# V1\_Drainage Report - Final\_Comments.pdf Markup Summary

PCD File No. SF-2239

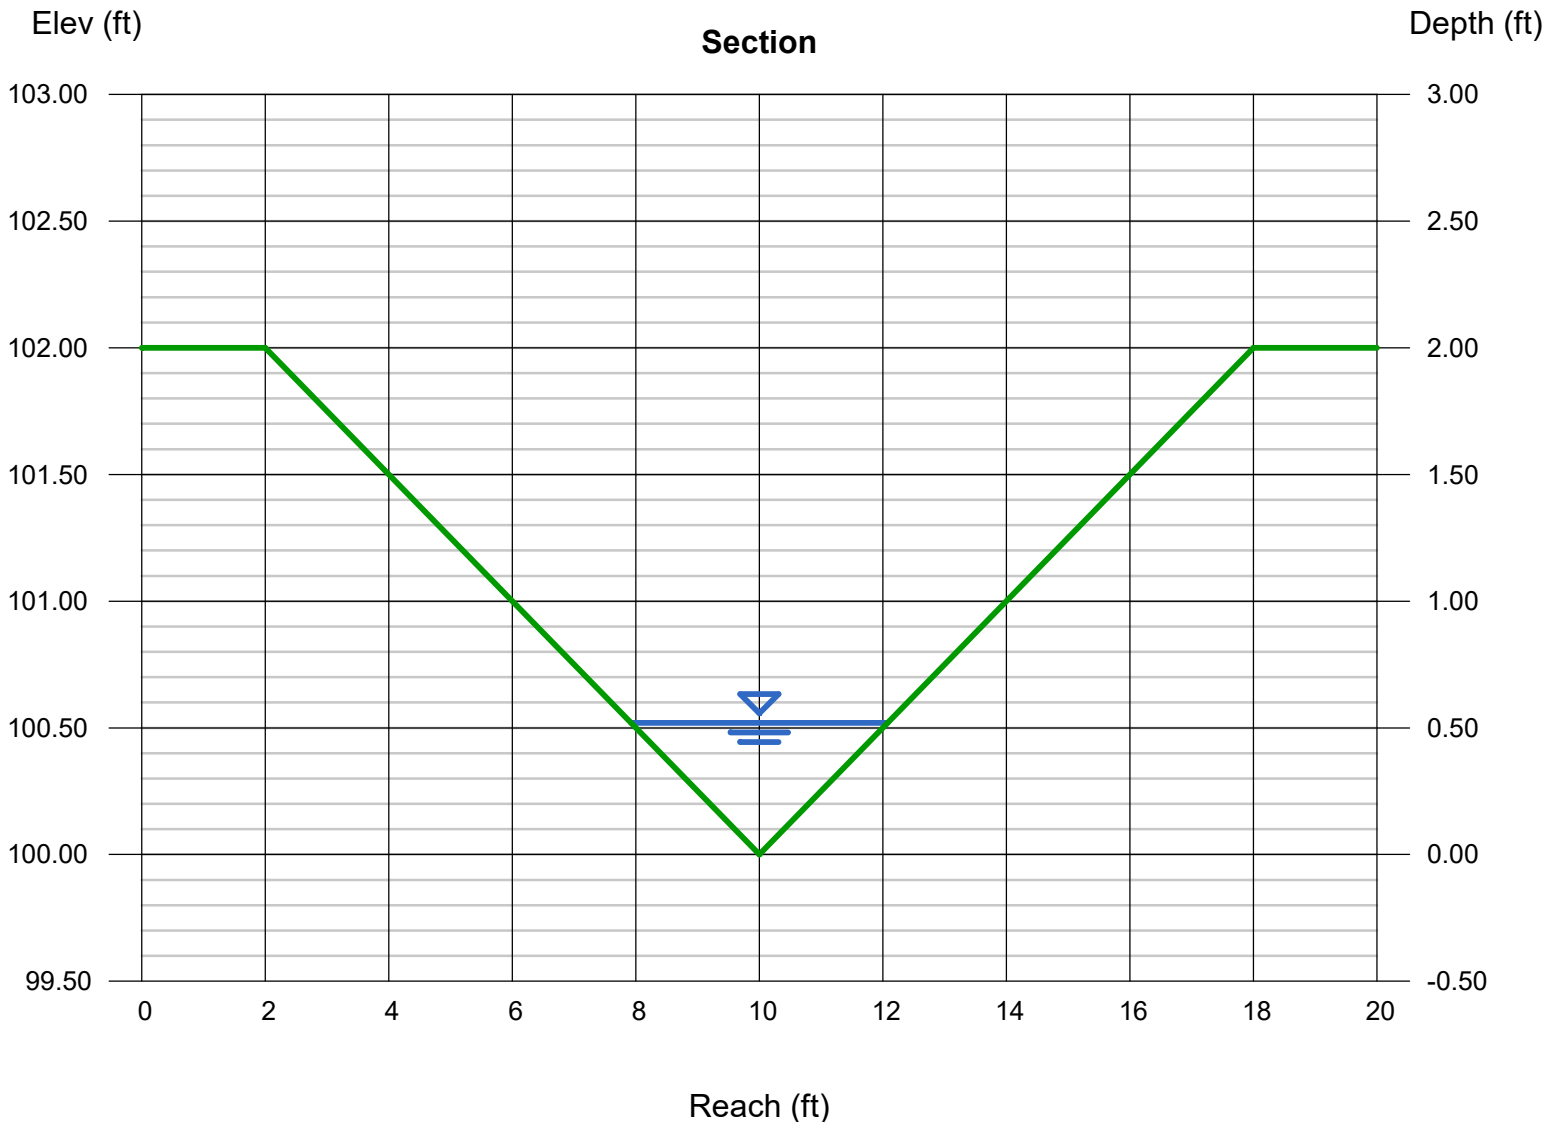
velocities exceeds the permissible velocity for native grass and will require a different treatment.

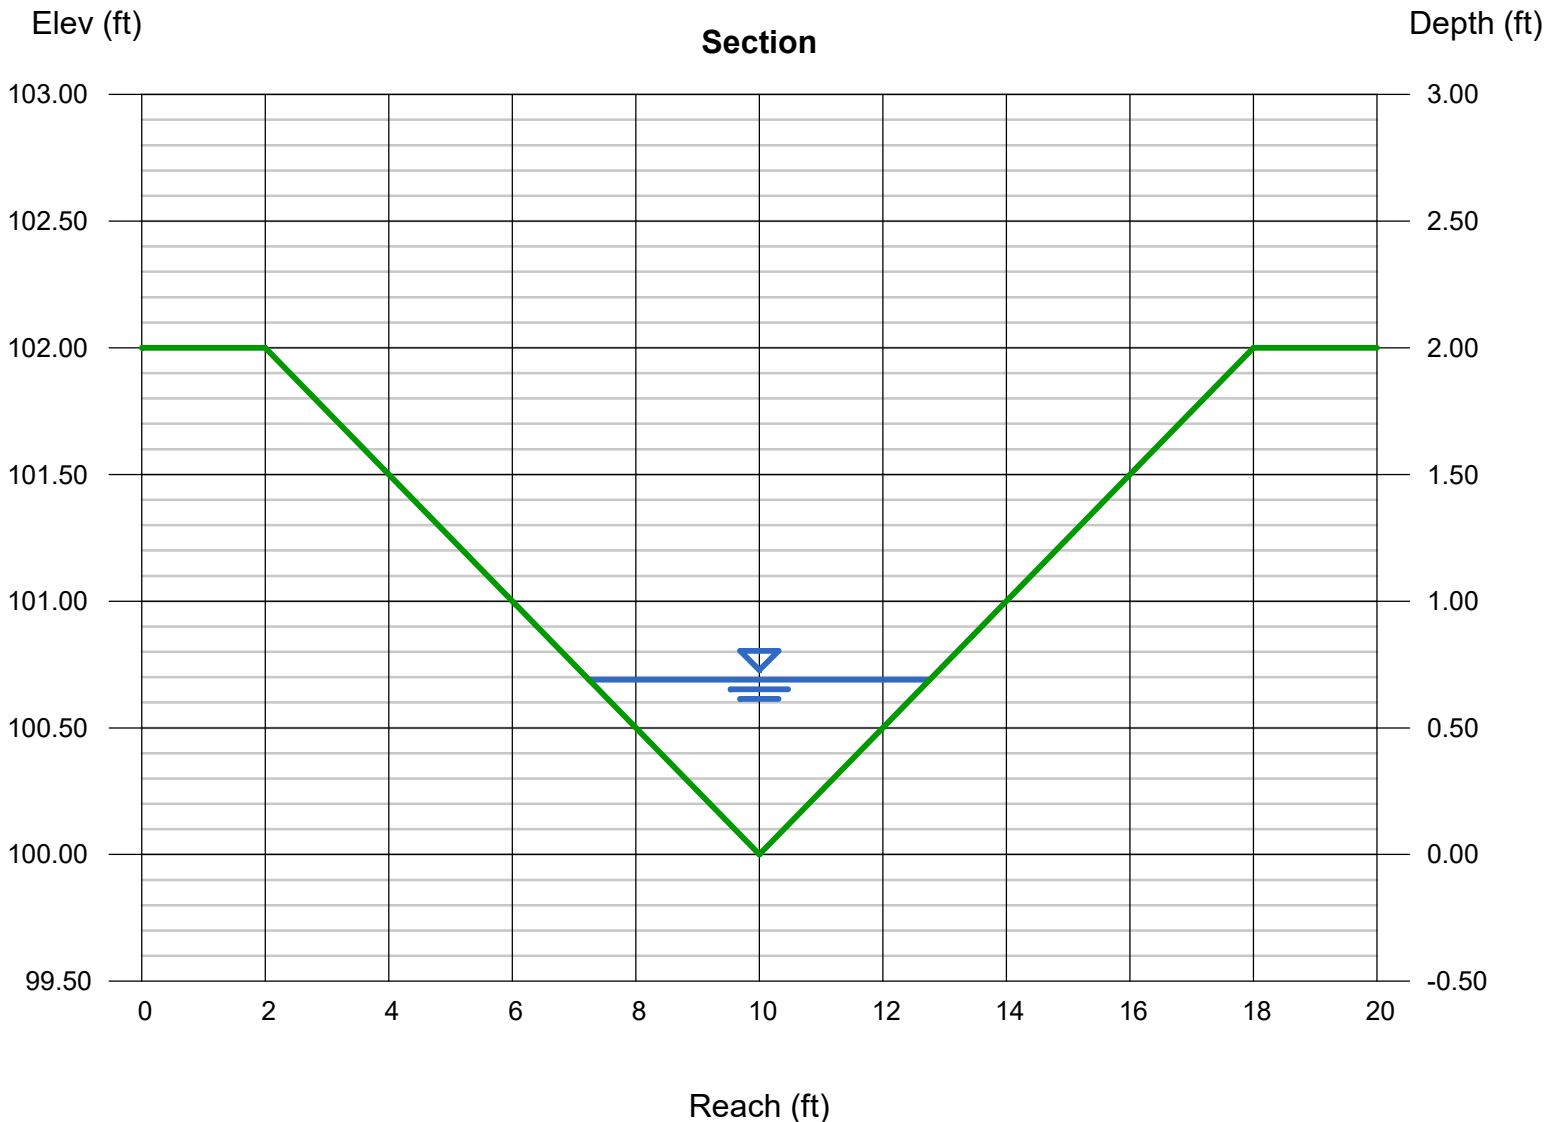
velocities exceeds the permissible velocity for native grass and will require a different treatment.

OFF-SITE BASINS

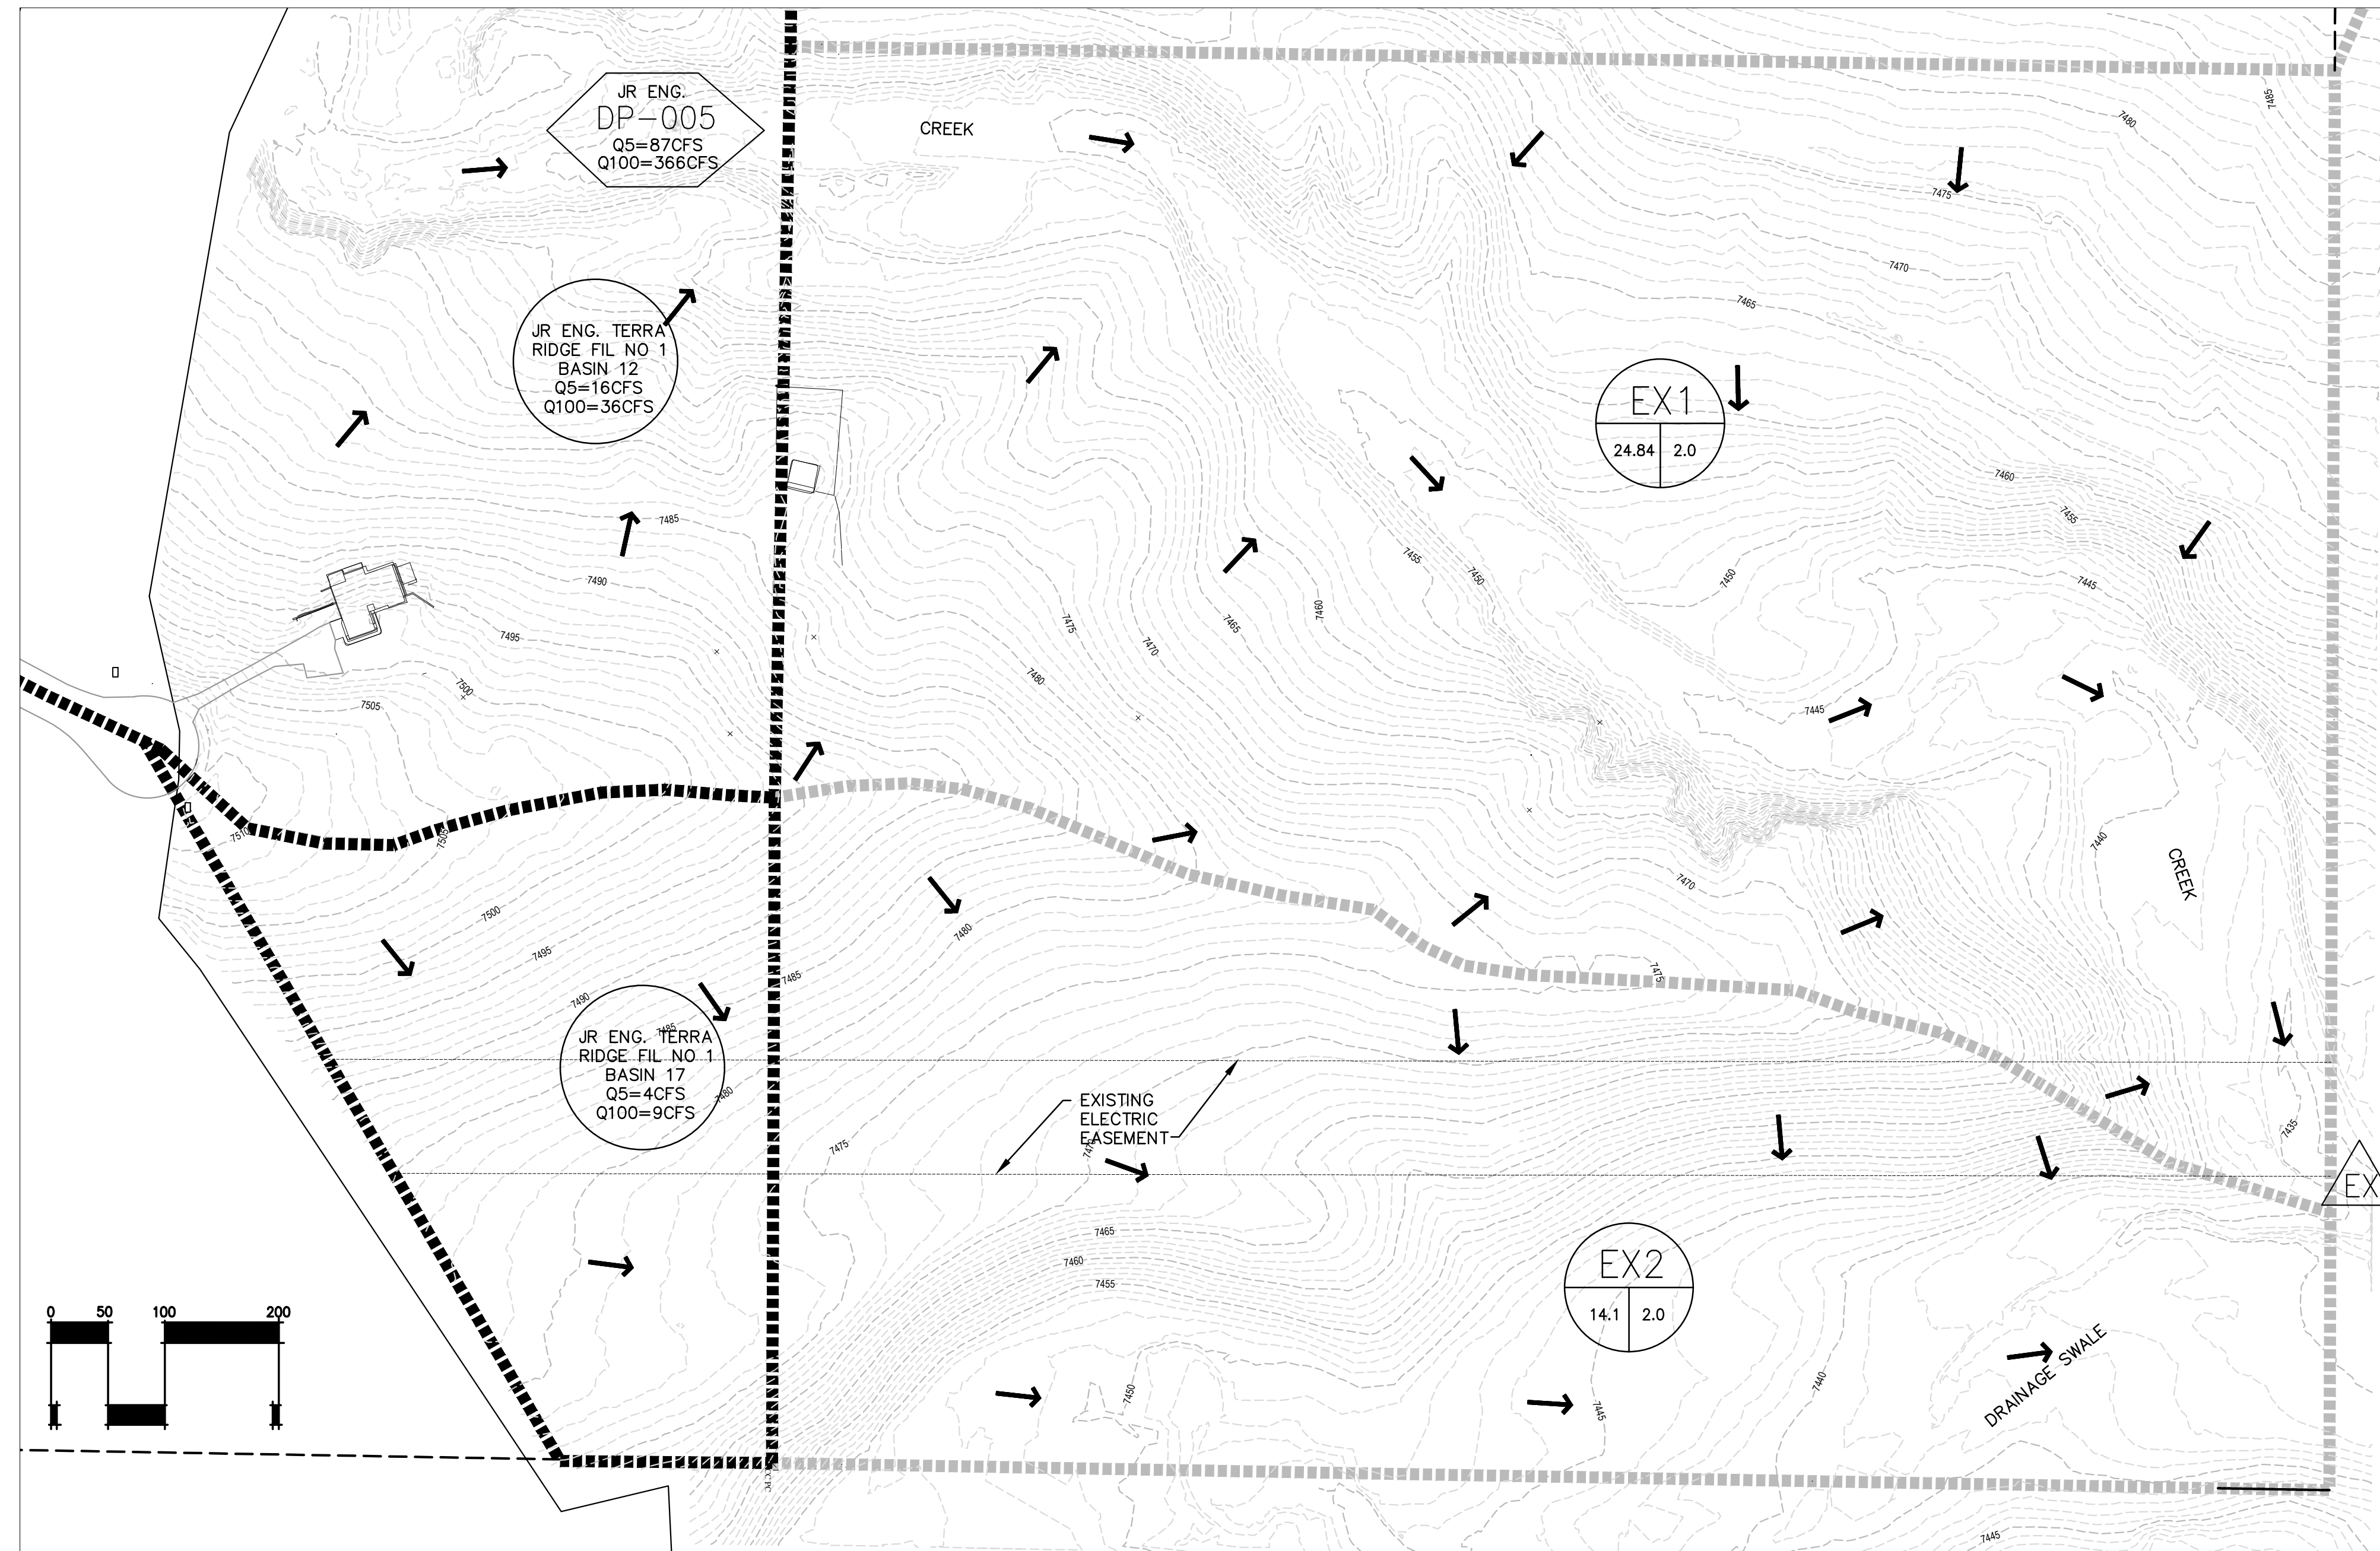
Add dark linestyle to legend. If it is just delineating basins keep linestyle consistent.

Show time of concentration paths on drainage maps.
